DRB Application No.: 05DRB-01885 (SBP)

Project Name: LADERA BUSINESS PARK
UNIT 2

CITY OF ALBUQUERQUE
Planning Department
December 21, 2005
DRB Comments

RE: Ladera Business Park, Unit 2/SBP

SHEET TITLE
SITE PLAN, SIGN DETAIL & NOTES

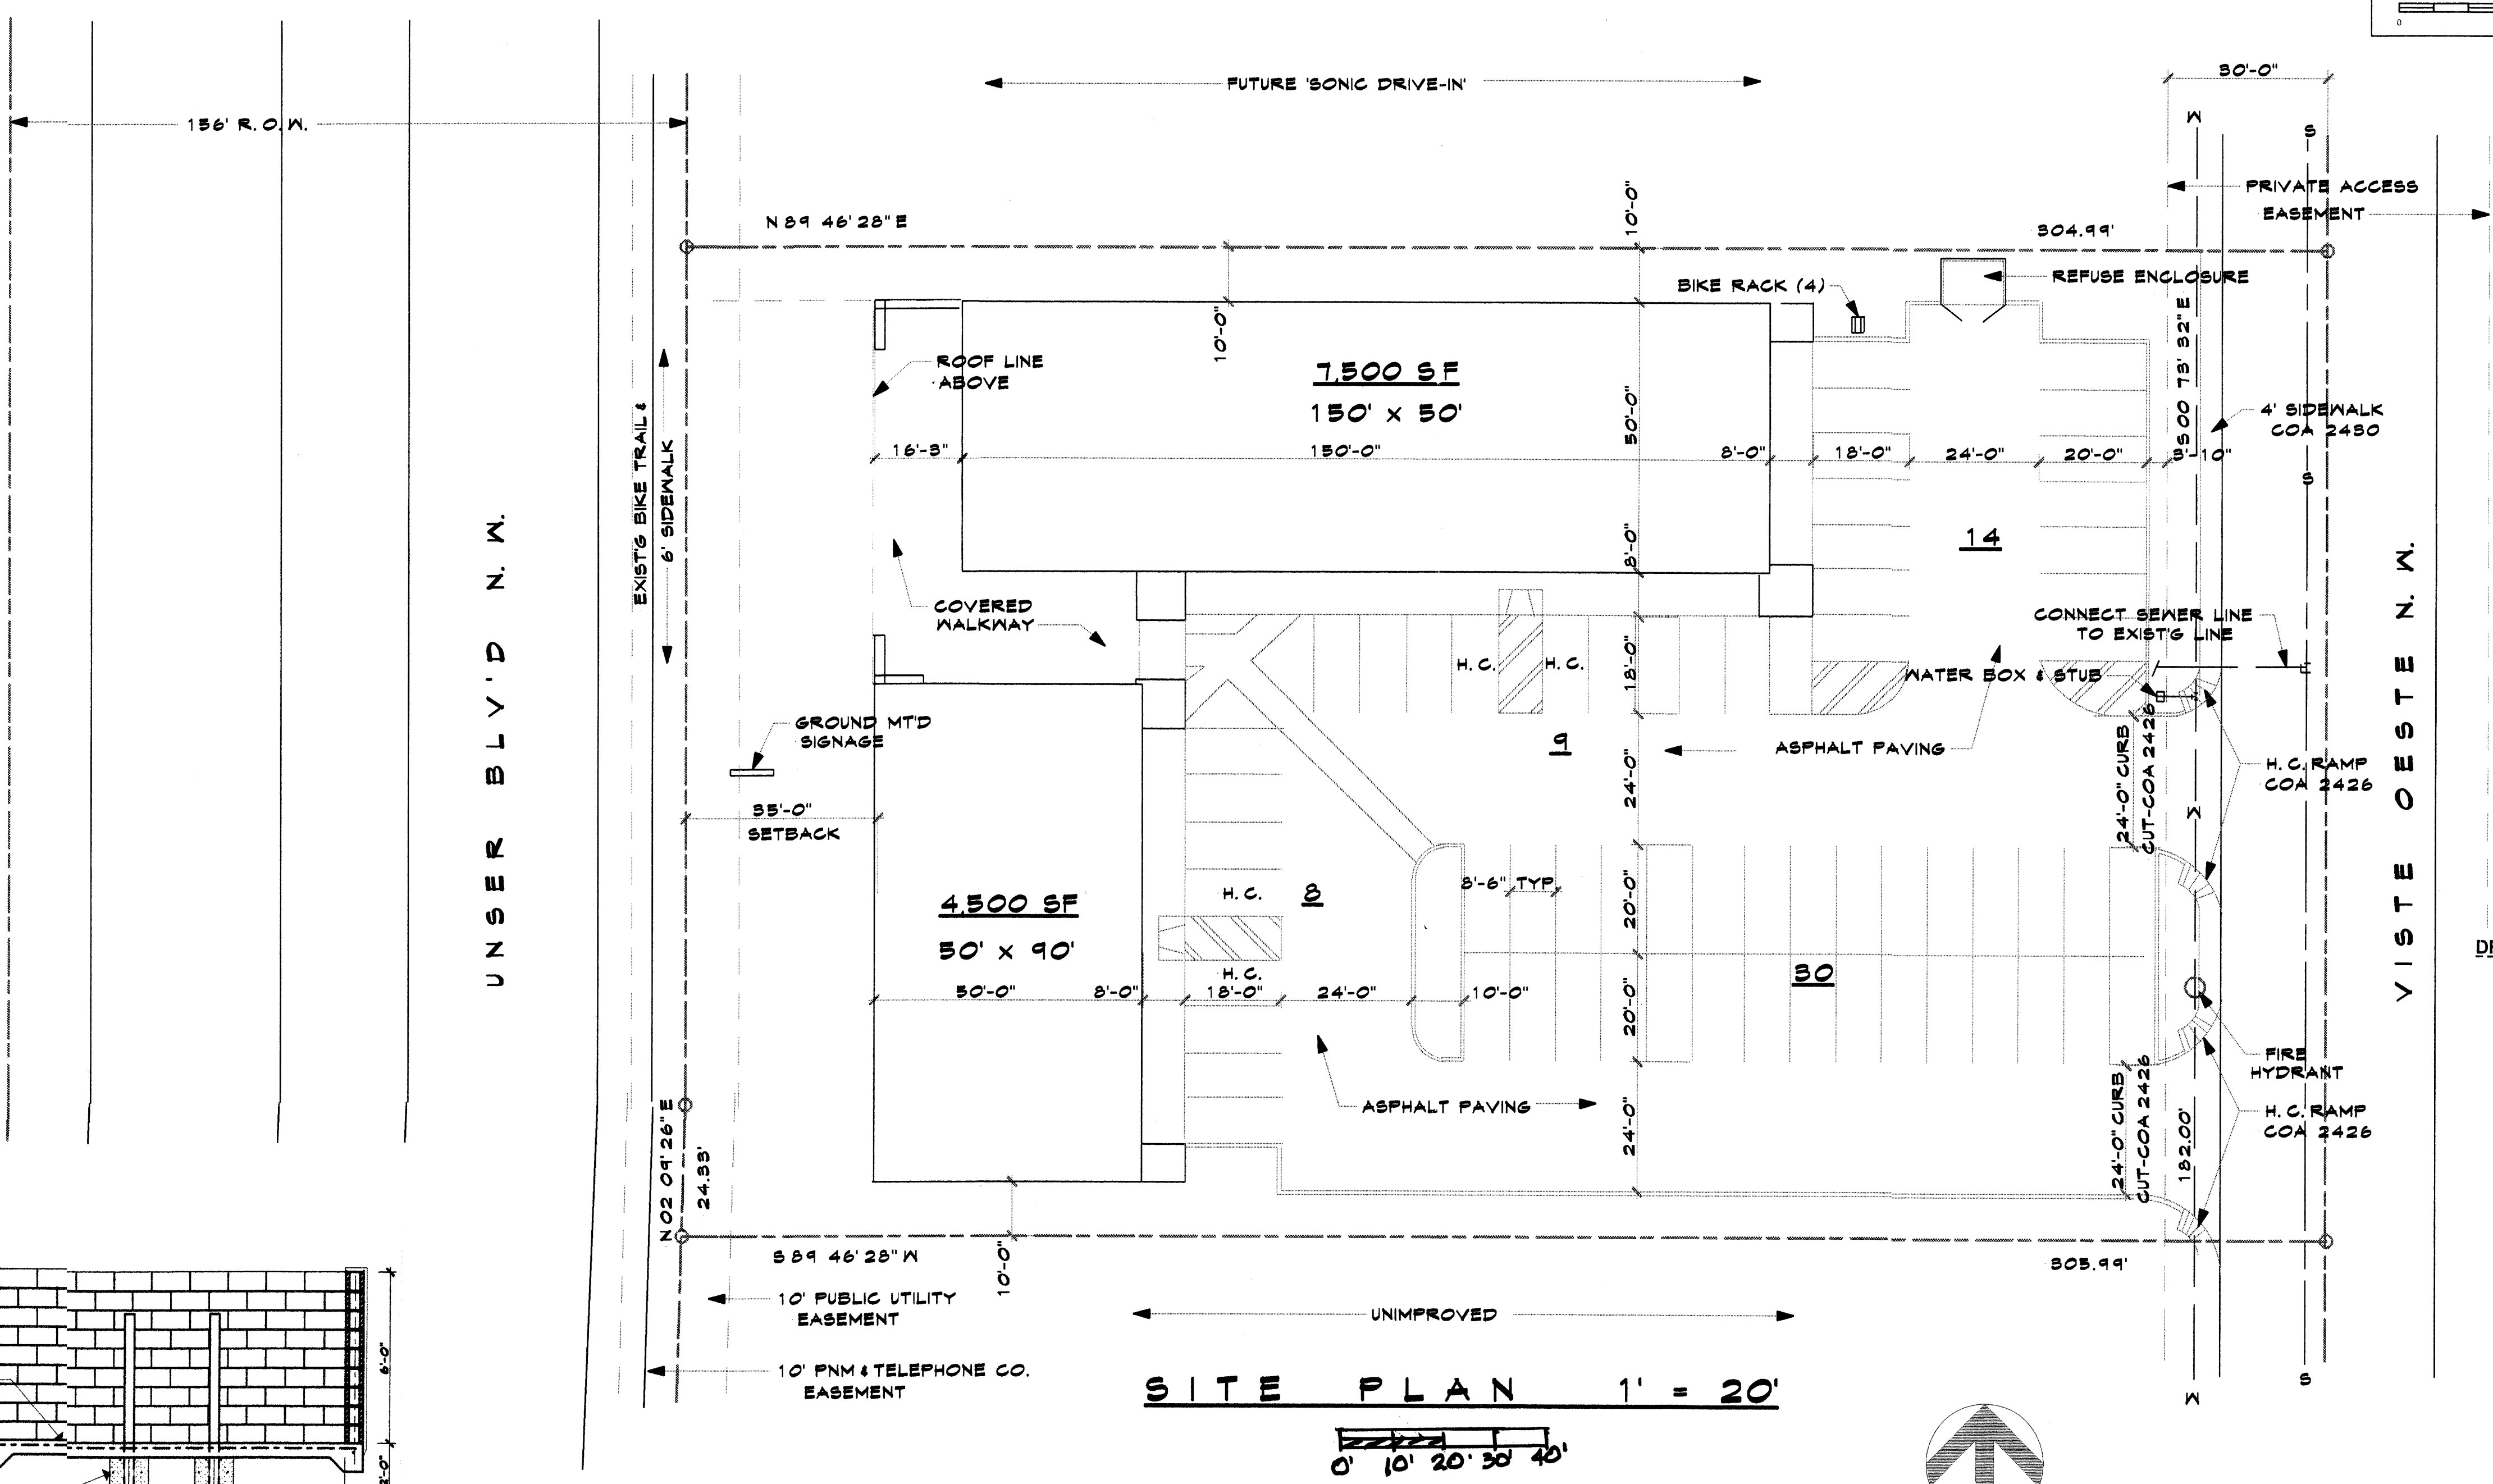
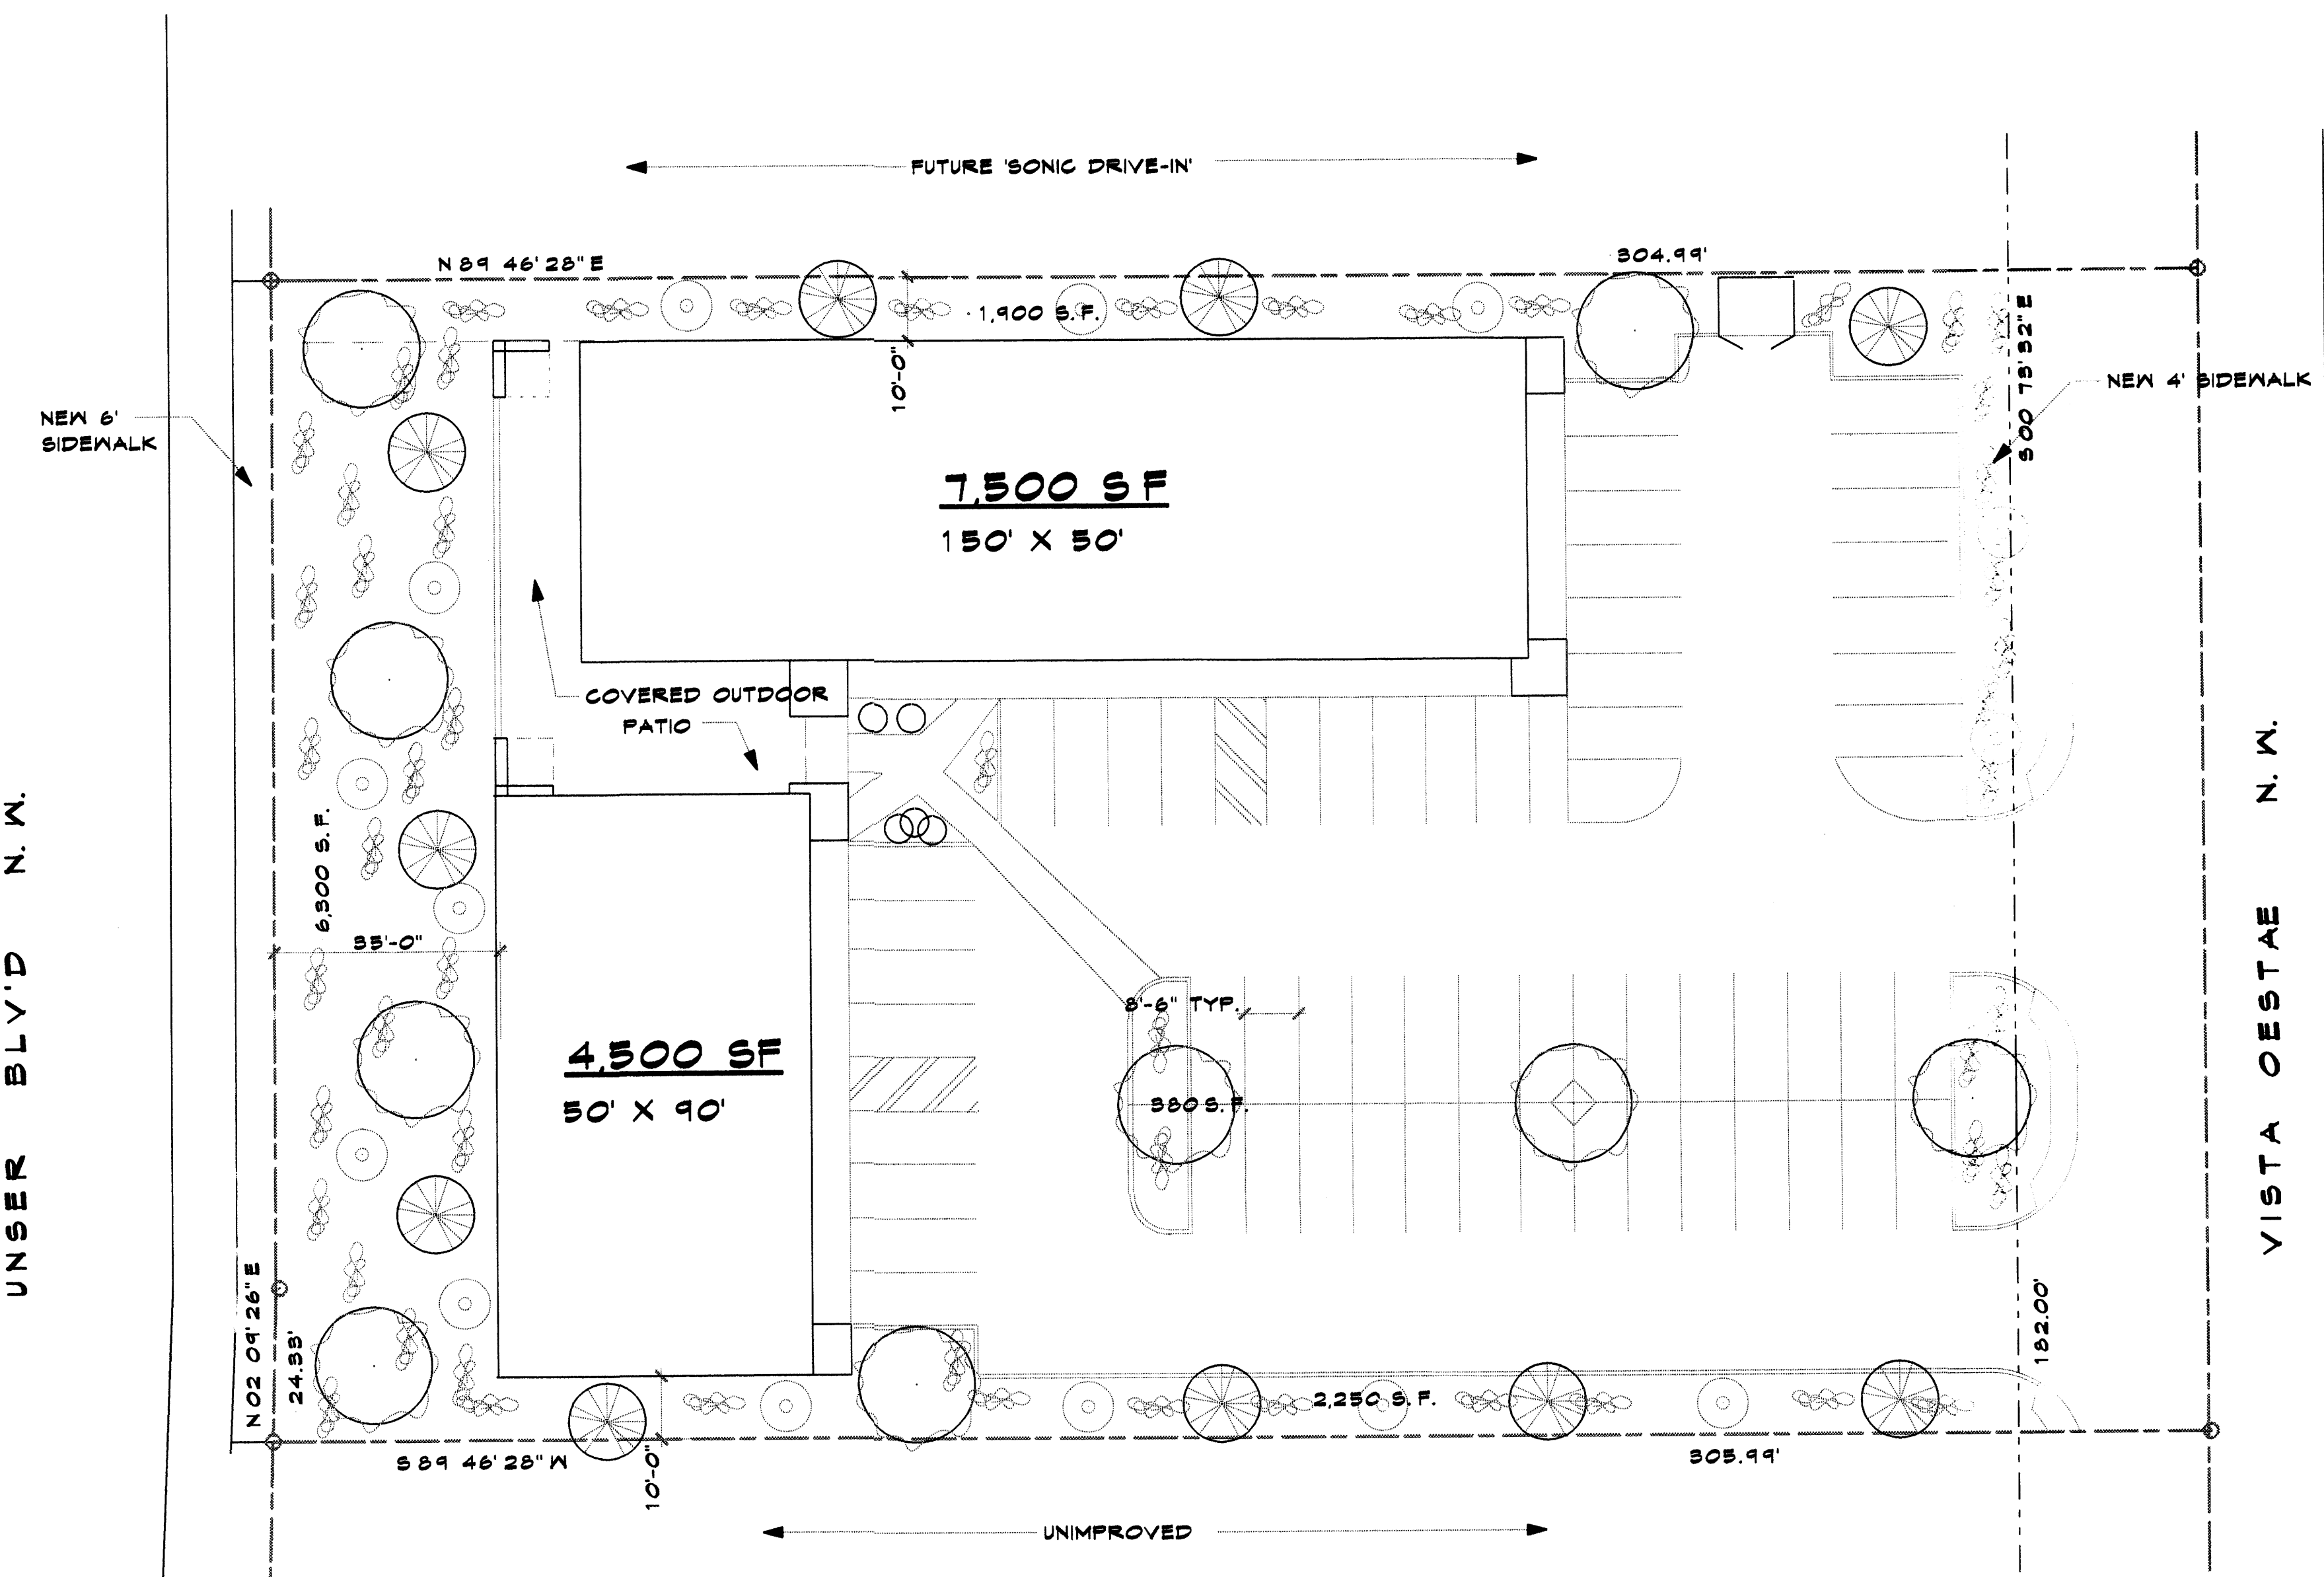
The site lighting is not shown on the Site Plan.

SITE LANDSCAPE PLAN 1" = 20'

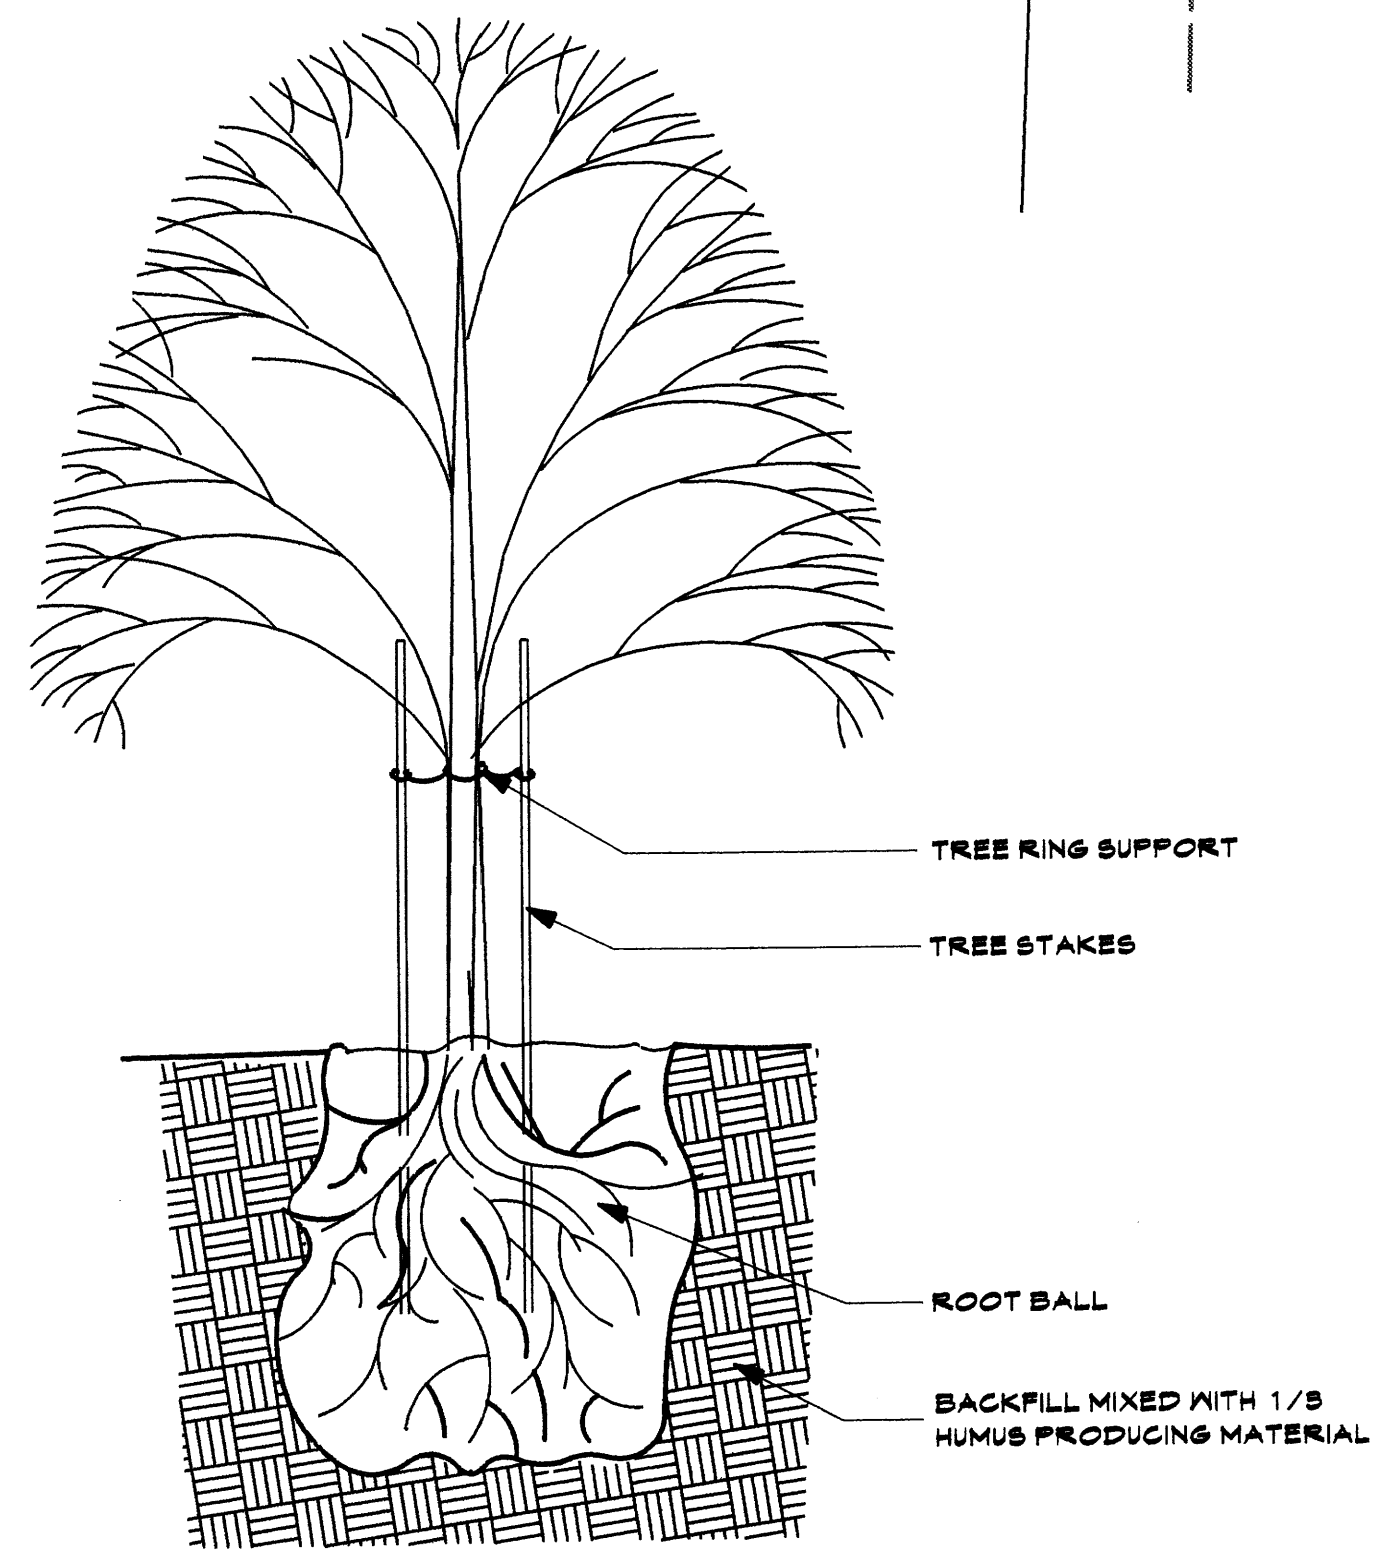
The number of plants on the landscape legend is not identified.

Please replace the tam juniper plant with an alternative ground cover plant.
